KRISTEN ESTATES FINAL PLAT CONSTRUCTION DOCUMENTS

EPC STORMWATER REVIEW COMMENTS
IN ORANGE BOXES WITH BLACK TEXT

KRISTEN ESTATES
EL PASO COUNTY, COLORADO
CONSTRUCTION DOCUMENTS
COVER SHEET

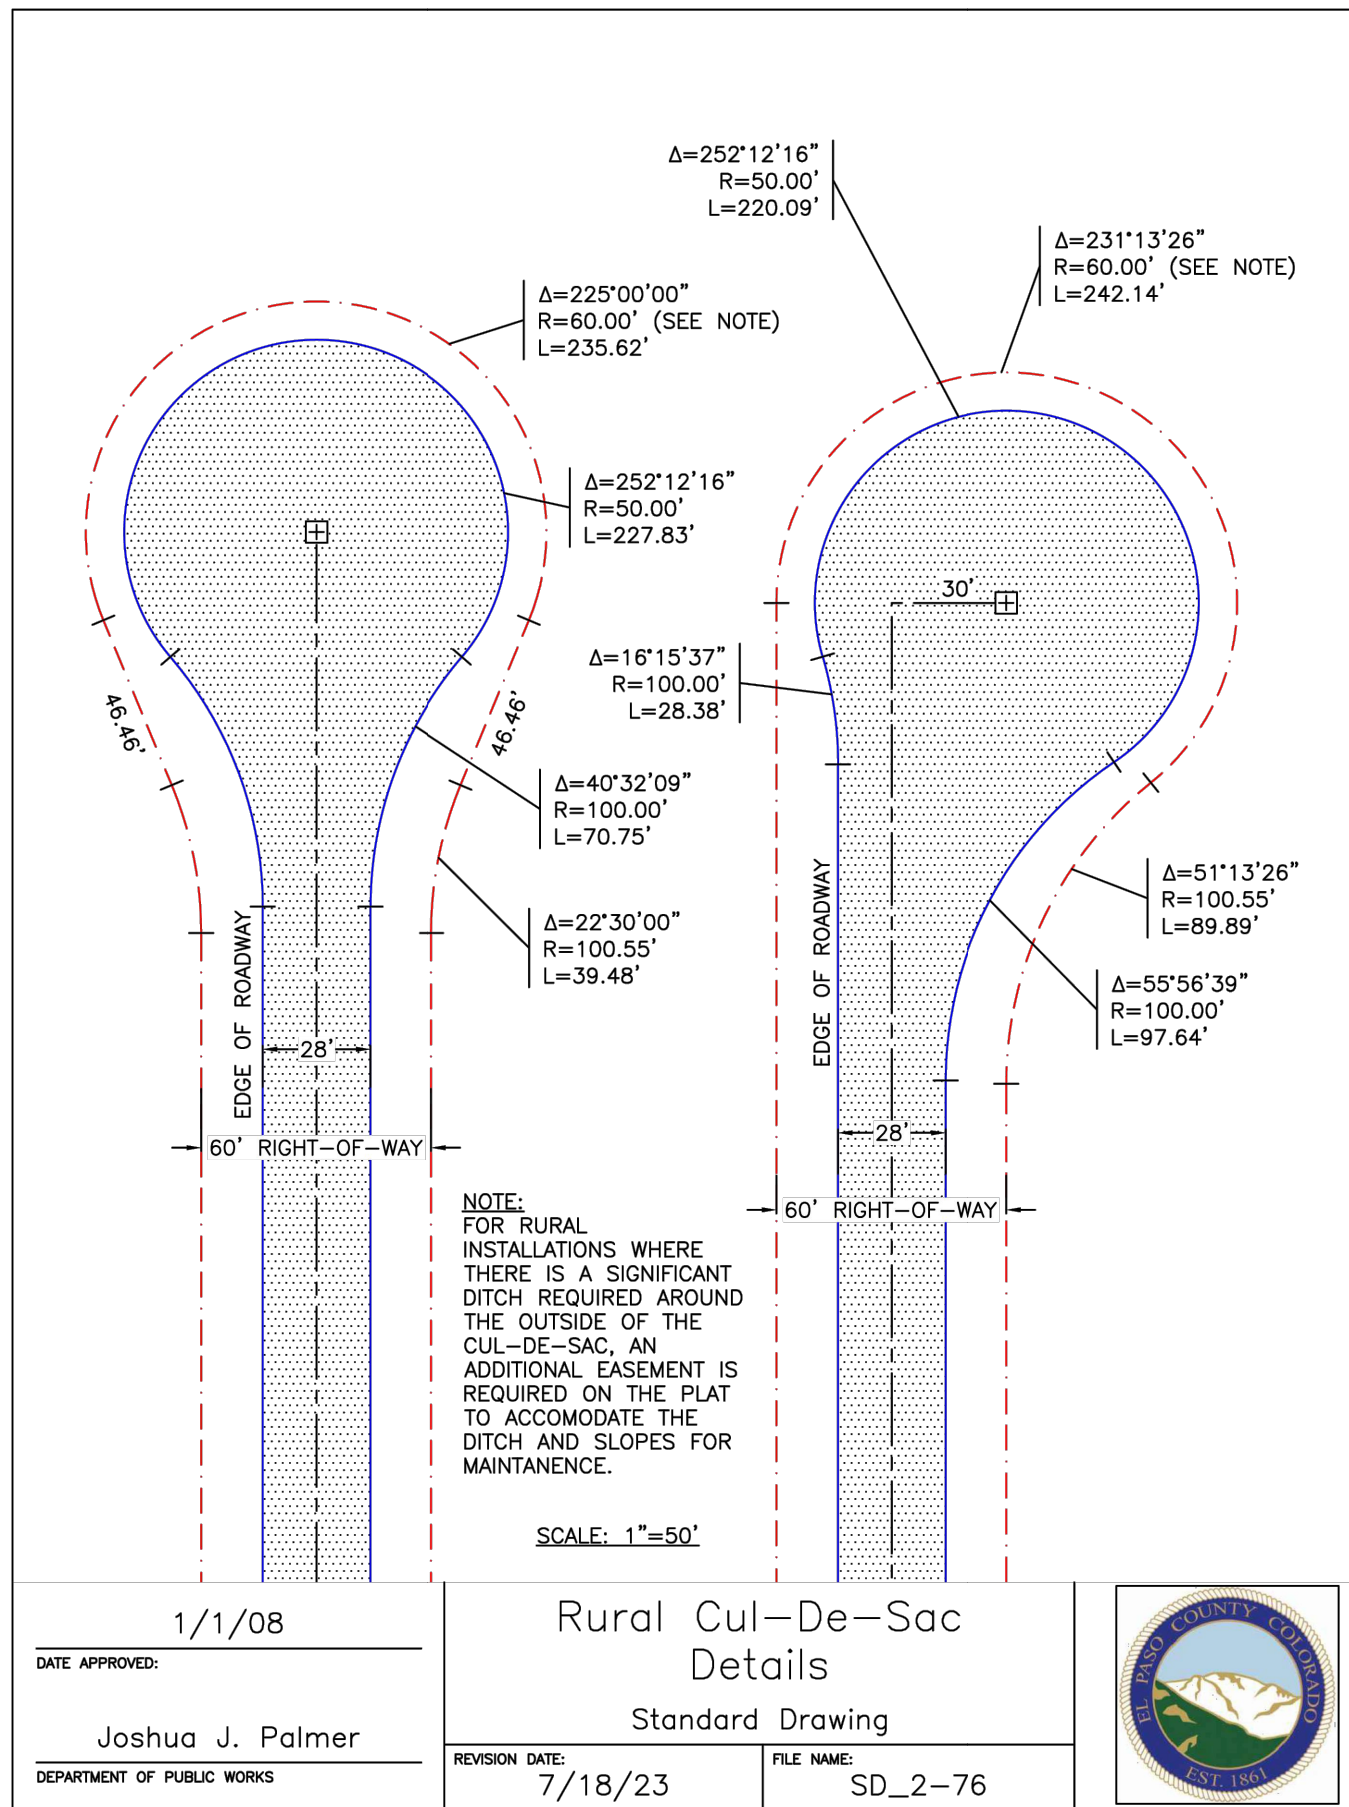
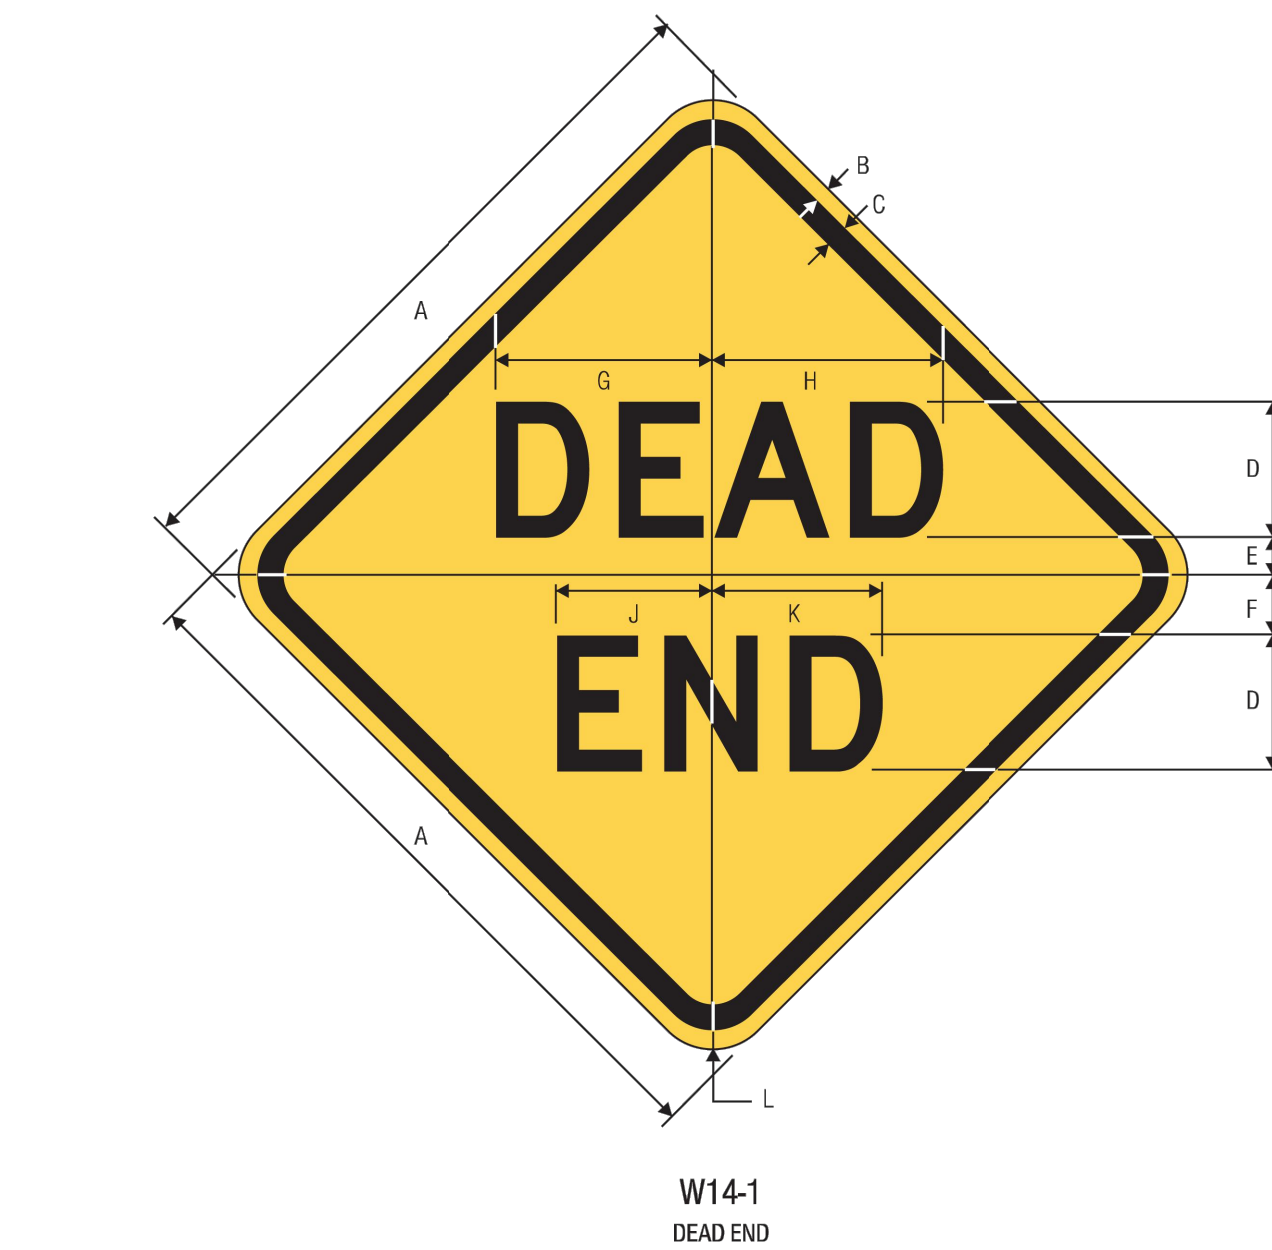
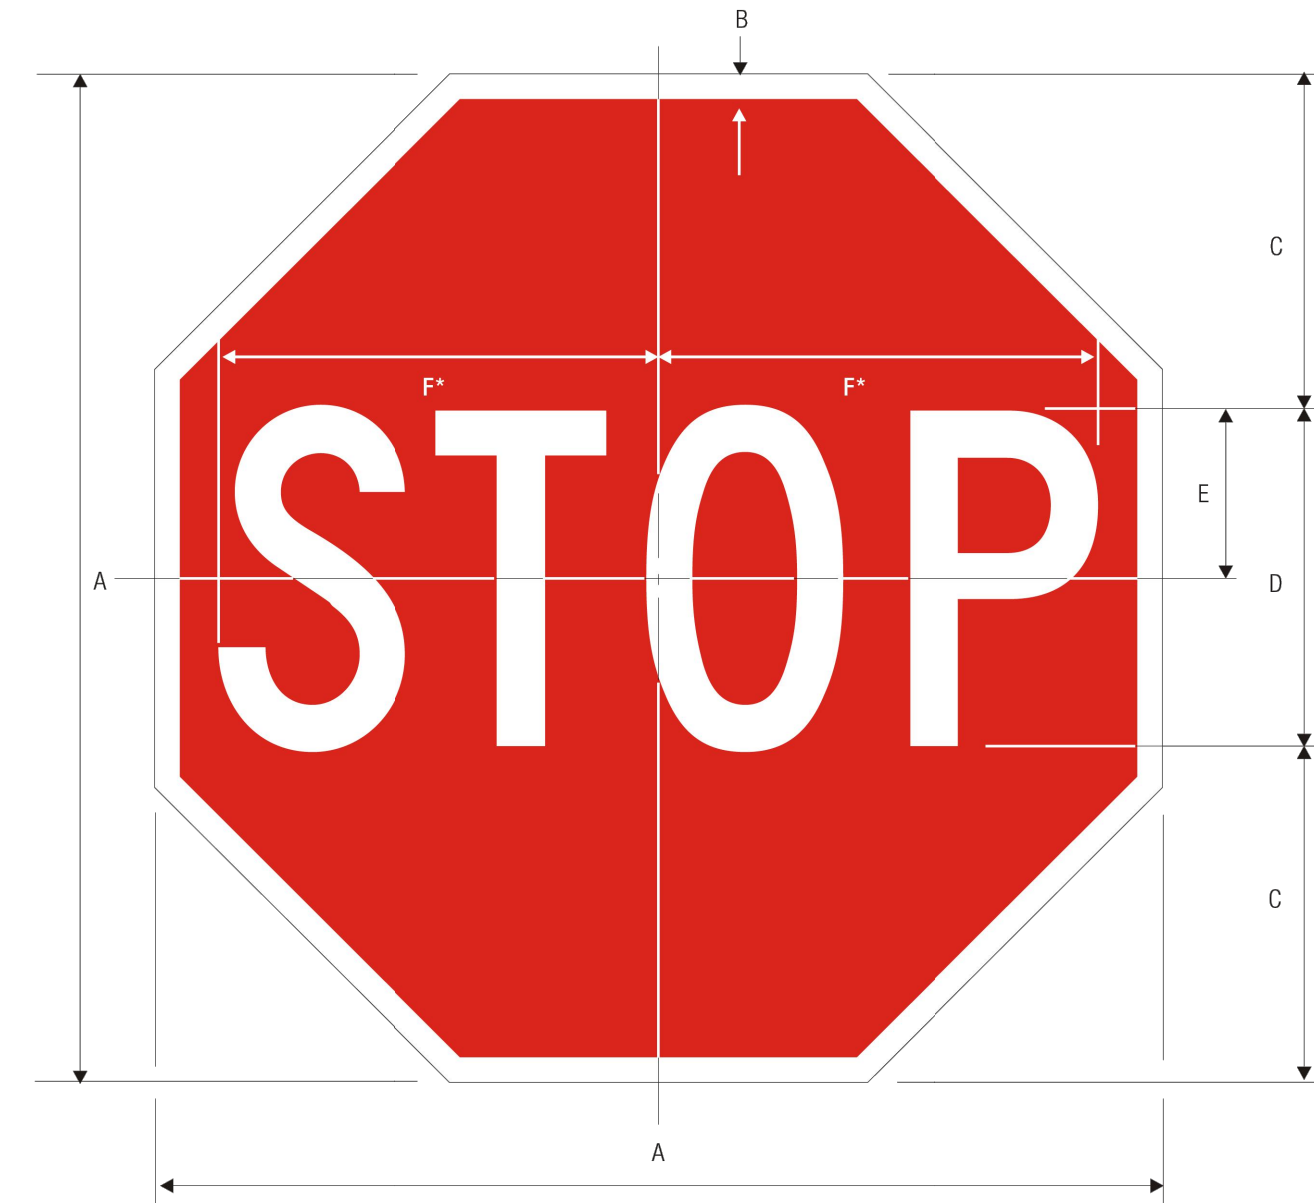
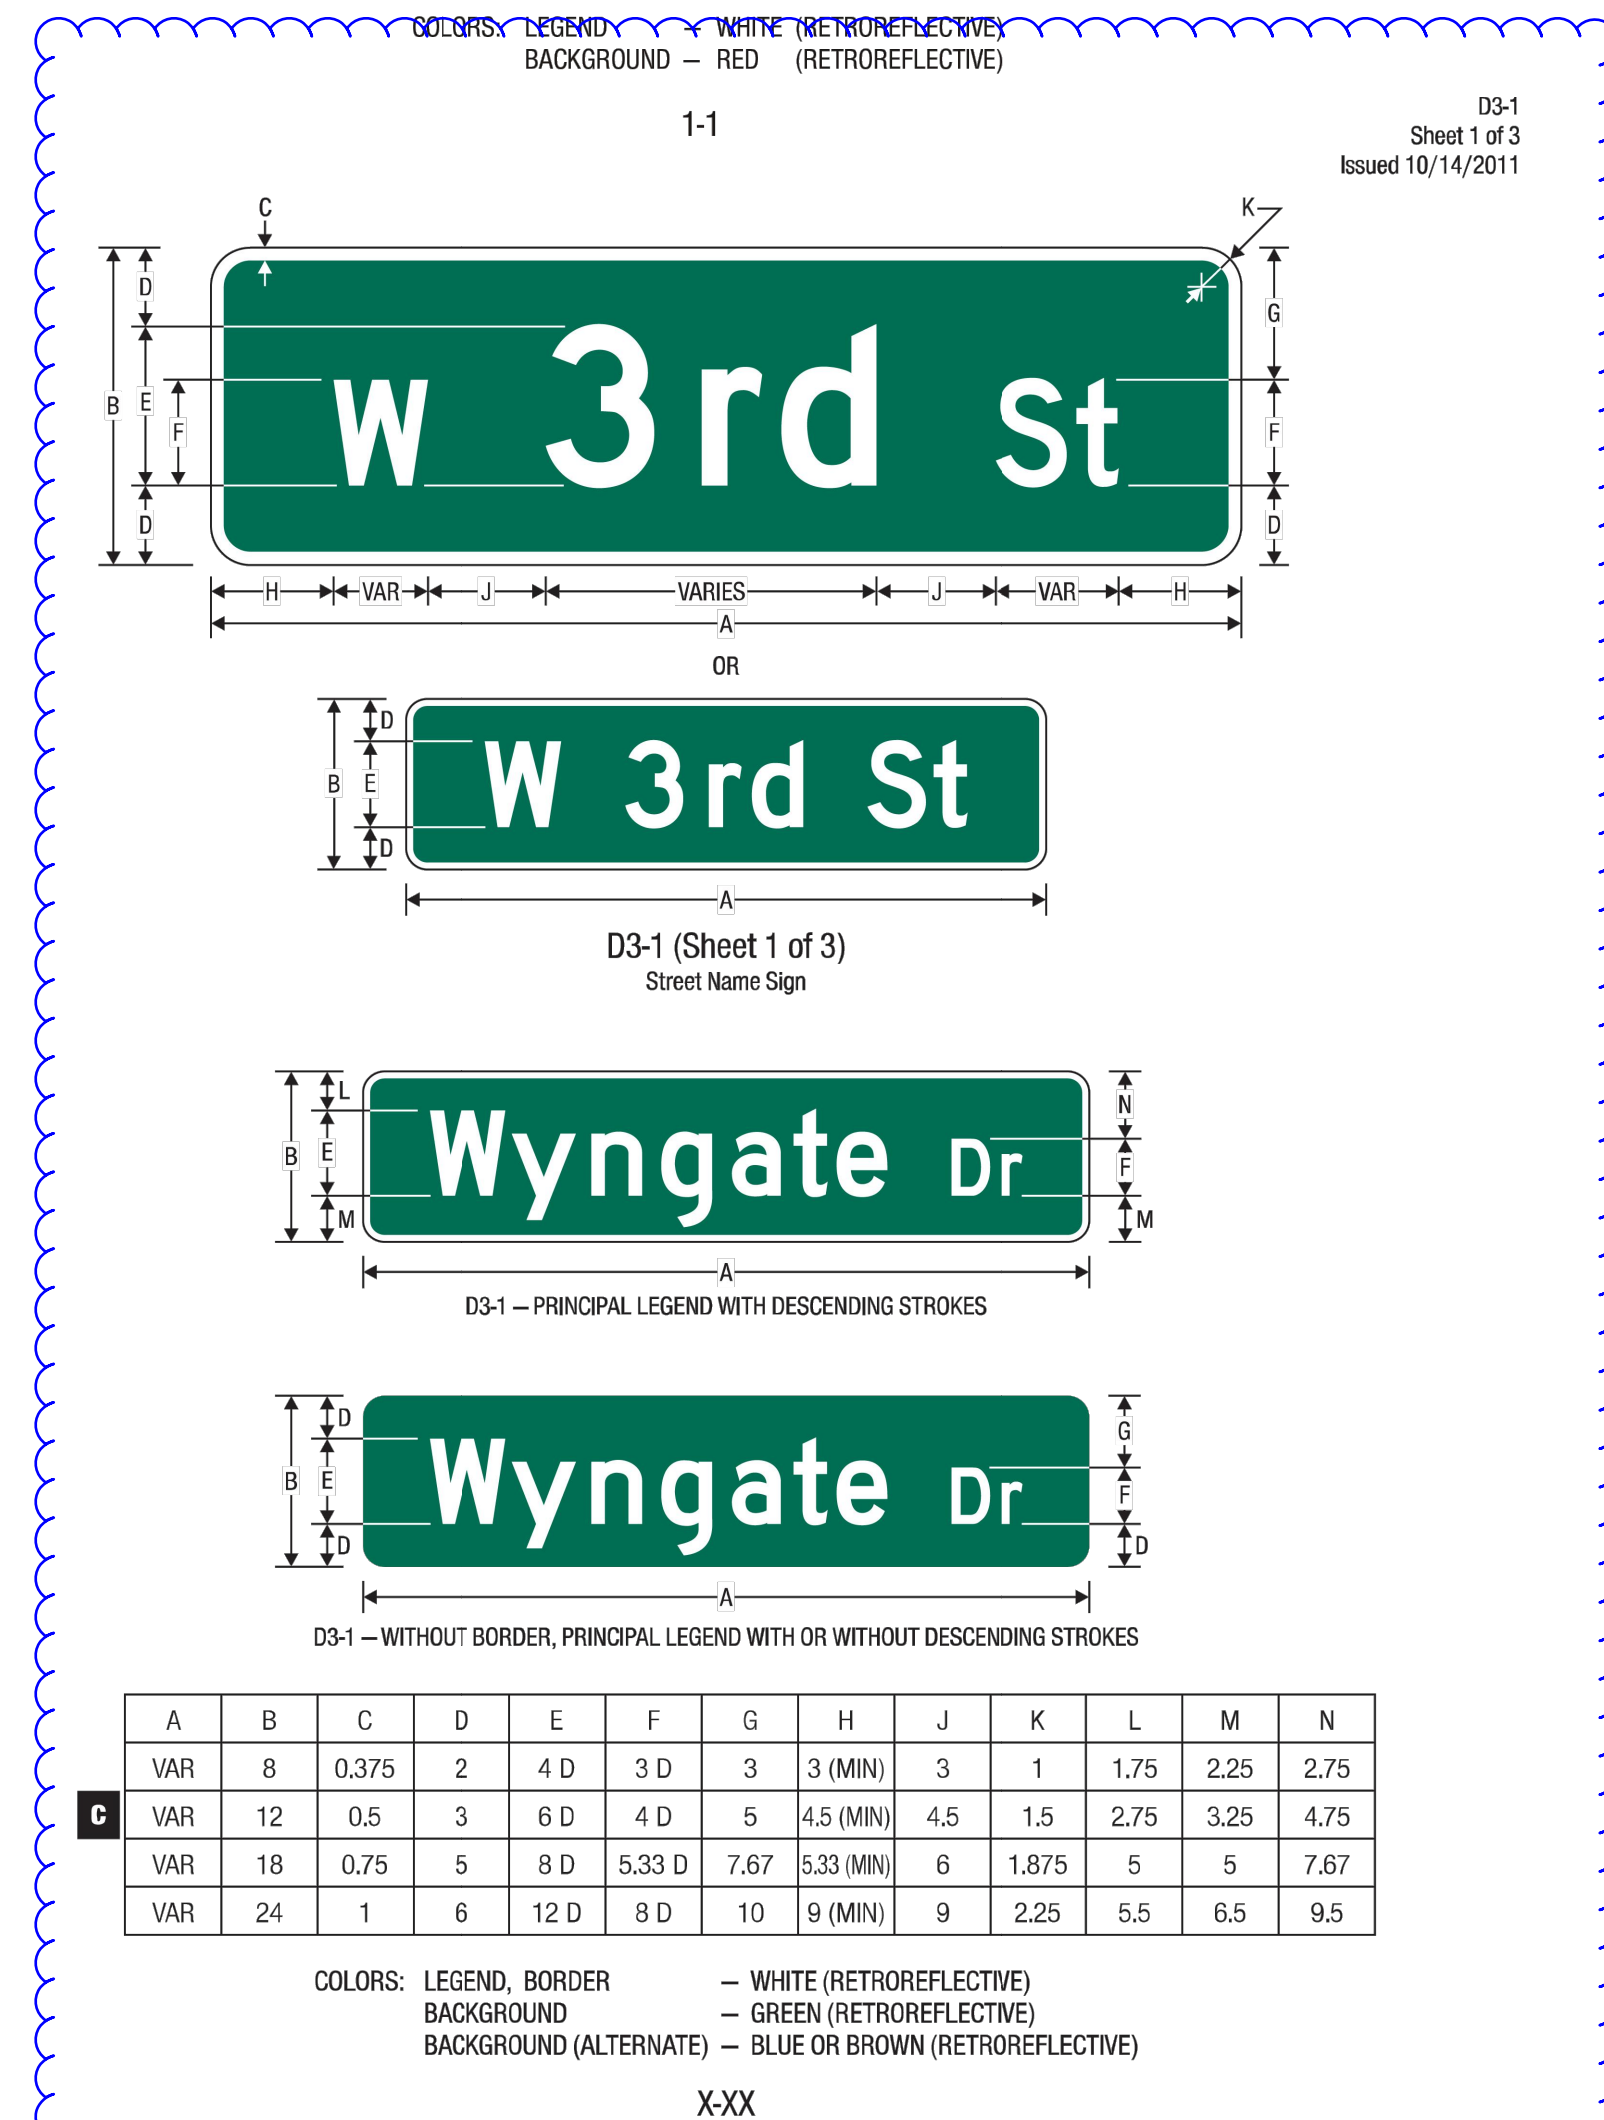
Please include detail and specs for private roadway signs. These have been uploaded in EDARP comments.

Provide a no outlet sign for cul-de-sac
